RESPONSE TO CHRIS BEMBRIDGE KIRKLEES COUNCIL
CONSULTATION REPORT (Dated 12/09/2024) & PARAGON
HIGHWAYS RESPONSE (Dated 14/01/2025)

Re: 2023/91280 Bromley Farm Quarry
Barnsley Road
Upper Cumberworth
Huddersfield HD8 8PD
February 2025

ACCESS TRACKING

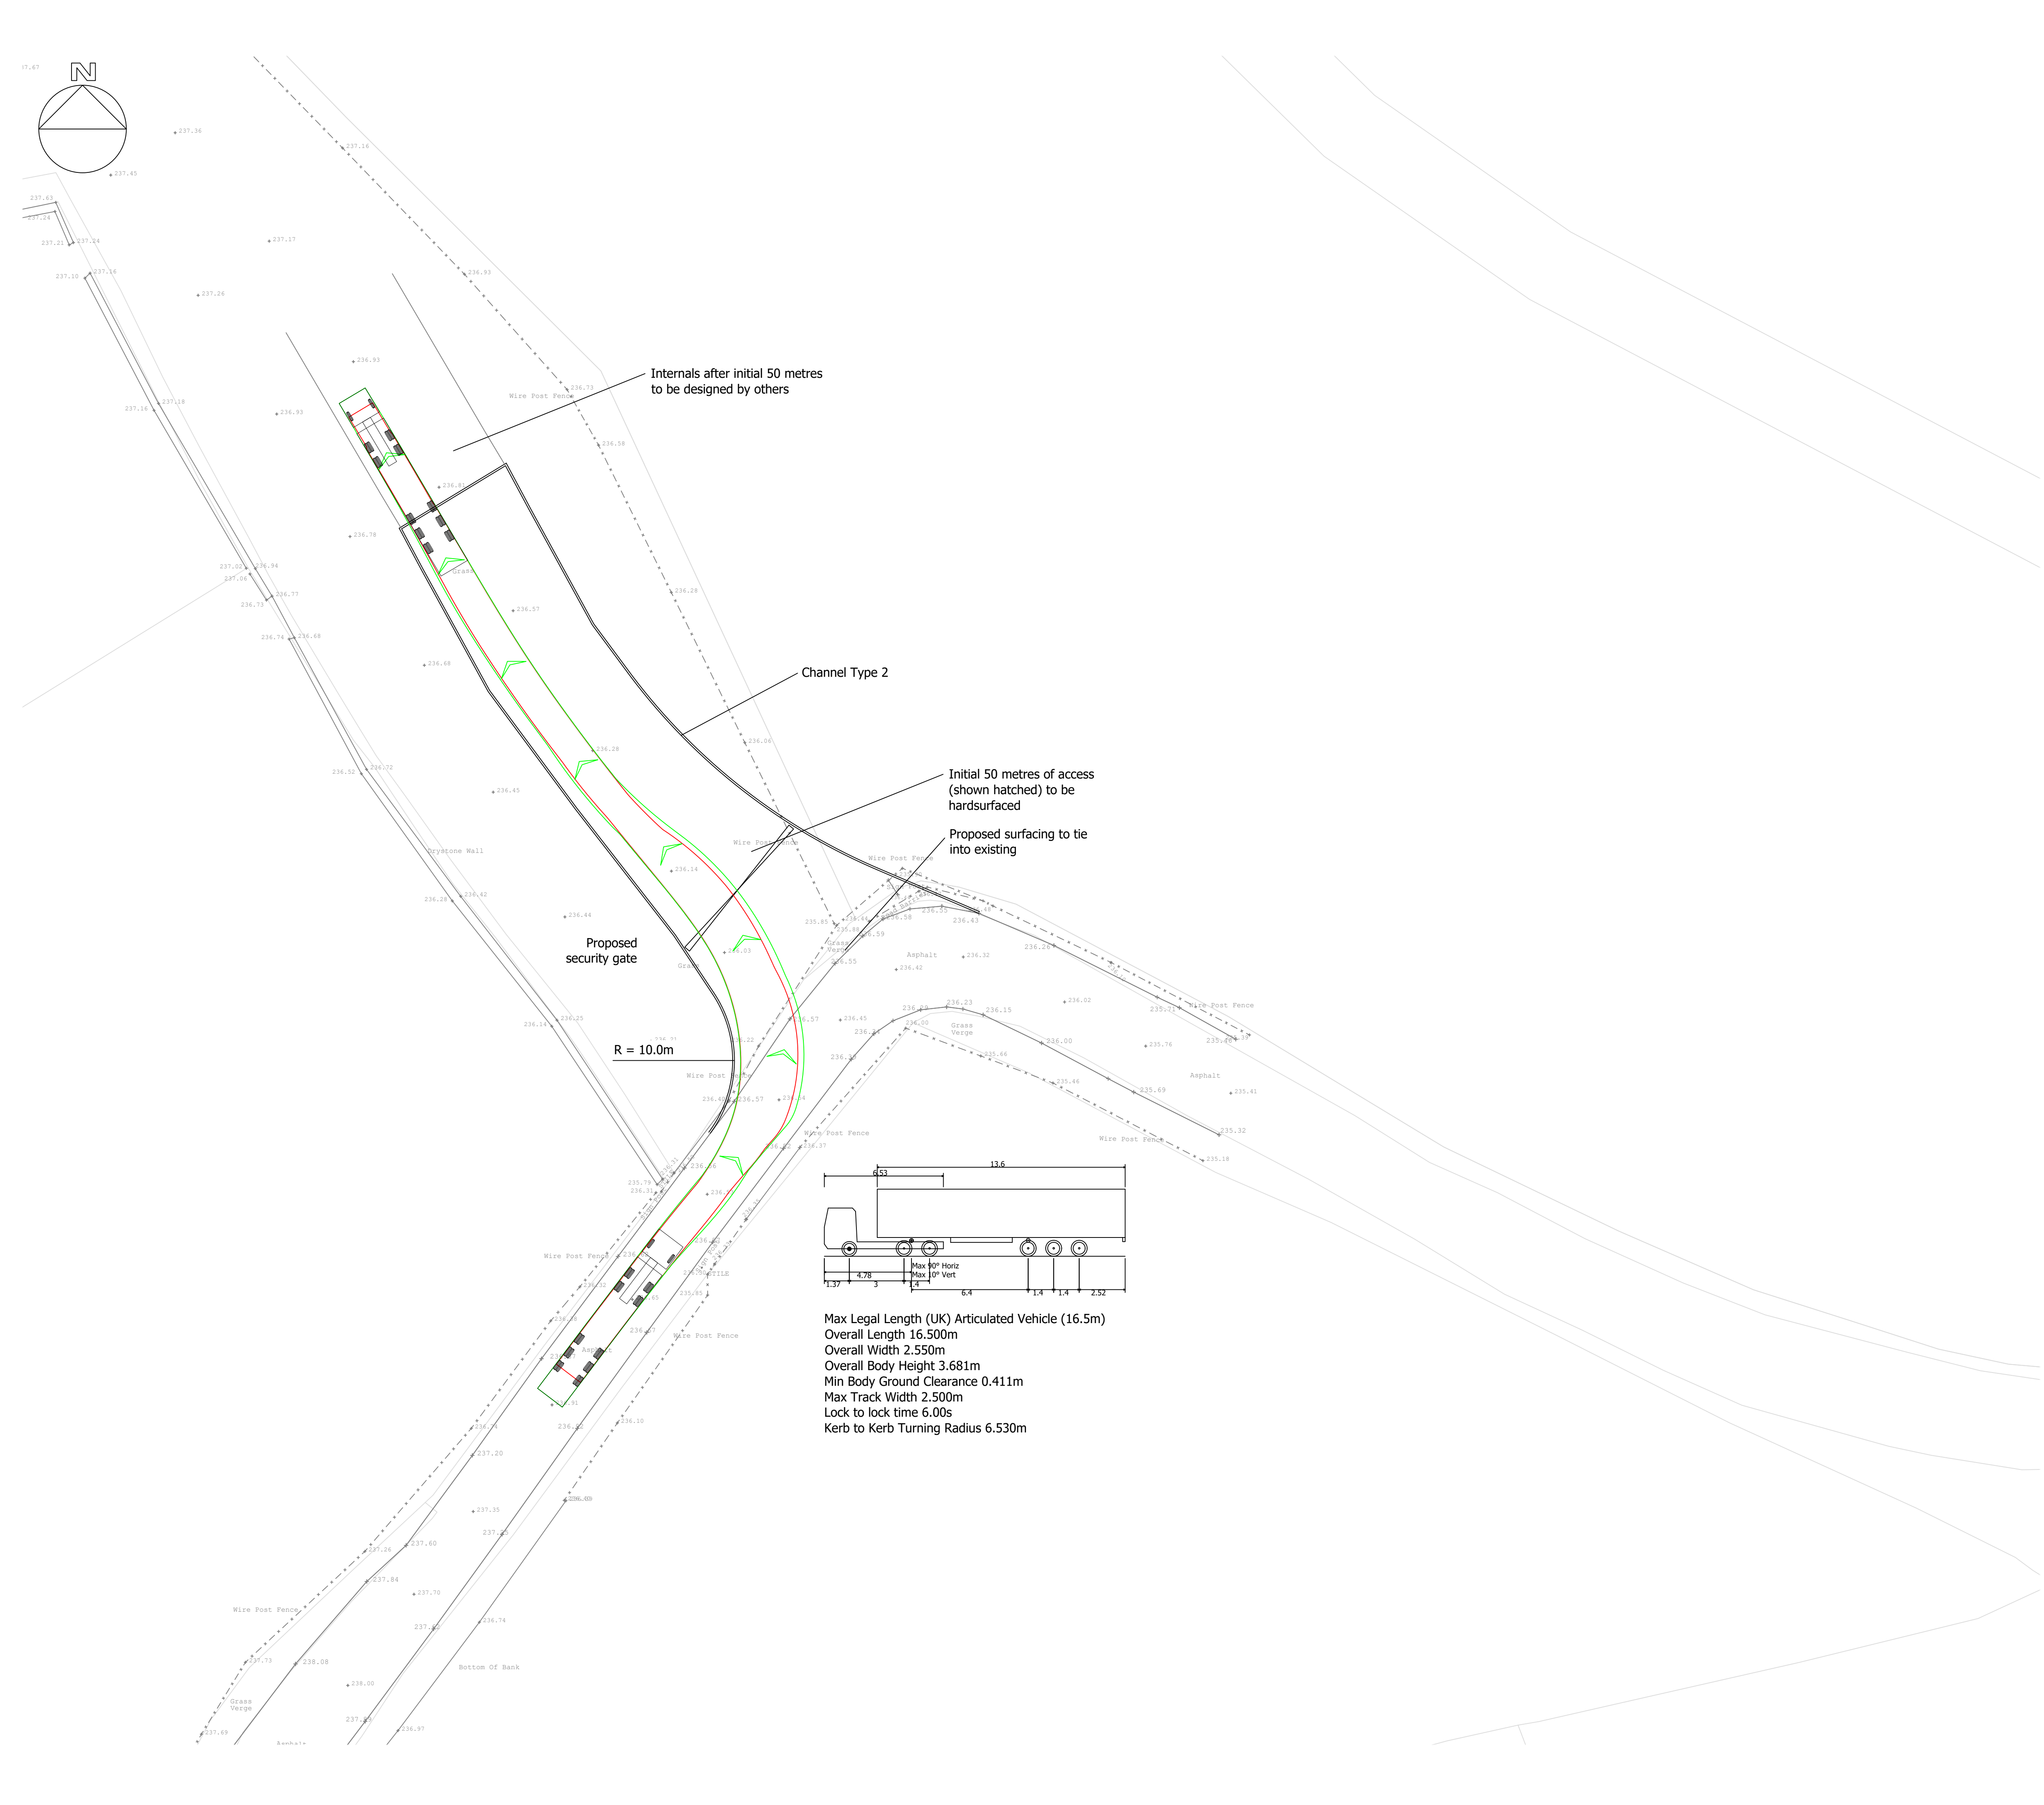
Access to the Site Paragraph 1	To suggest that the existing bell mouth access would be acceptable is very misleading; with excess HGV movements no consideration has been taken for pedestrians. Vehicles are mentioned again, what type? there is a big difference between rigid and articulated. There should be no comparison with the past 5 years, this junction will experience a totally new concept with the increase of HGV's either rigid/articulated? so it would be wrong to assume that the junction would operate safely. Conclusion: Have KC satisfied themselves that the kerb radius is now 10m; it would have been more productive if a site visit had been conducted and other issues could have been identified, instead of looking at maps/erial photographs. In practice there are times when it is not correct to compare the last 5 years, in order to justify

Paragraph 1 (Con'td) Access to the Site Paragraph 2	your statement where are the Risk Assessments? The route proposed for the removal of the main mineral would not use this right turn lane in normal use. Conclusion: Transparent statement, yes you are correct, but what you fail to mention the delivery of inert material. The answer to this question will not be known until the quarry is in operation. Inert material is not usually stockpiled and dug as virgin soil.
Paragraph 3 – 5	In these paragraphs KC have highlighted there are <u>highway</u> safety concerns with the current use of the access driveway and with the expected intensification of use we expect that these concerns will increase. Conclusion: Incorrect statement, this road will no longer be a <u>highway</u> because it is will be used in conjunction with the quarry access, the Health & Safety Executive states for 'Quarry Vehicles and Edge Protection' the road needs to be wide enough to allow vehicles to pass with ease, for two-way roads they should be three and one times the width of the largest vehicle using the road, these are the minimum acceptable widths. Therefore width of road needs to be 8.92 metres wide. KC recommendation of 6m is incorrect and is extremely inaccurate. Again where are the Risk Assessments, this would be a requirement when you using a shared public access to Bromley Farm Household Waste Recycling Centre.

Paragraph 7	The gate relocation to be setback approximately 17m from the edge of the existing shared driveway. Conclusion: KC are assuming there will be only one vehicle waiting to enter the site, from experience this is incorrect, any more than one vehicle would be a risk to people using BFHWR the entrance to the quarry is on a bend, again Risk Assessments required.
Paragraph 8	In this paragraph it has been confirmed by the applicant that 16.5m articulated six axle vehicles as being the type expected to operate at the quarry. Conclusion: Ambiguous statement, in this same report under 'Trip Generation' paragraph 5, the type and size of vehicle to be used was to be confirmed. Now appears we are using a 16.5m articulated vehicle with a pay load of 44 tonnes, which would require a whole new appraisal of the access road as this vehicle will not be able to park in the existing laybys previously mentioned. A rigid and articulated vehicle is completely different in the way they are used.
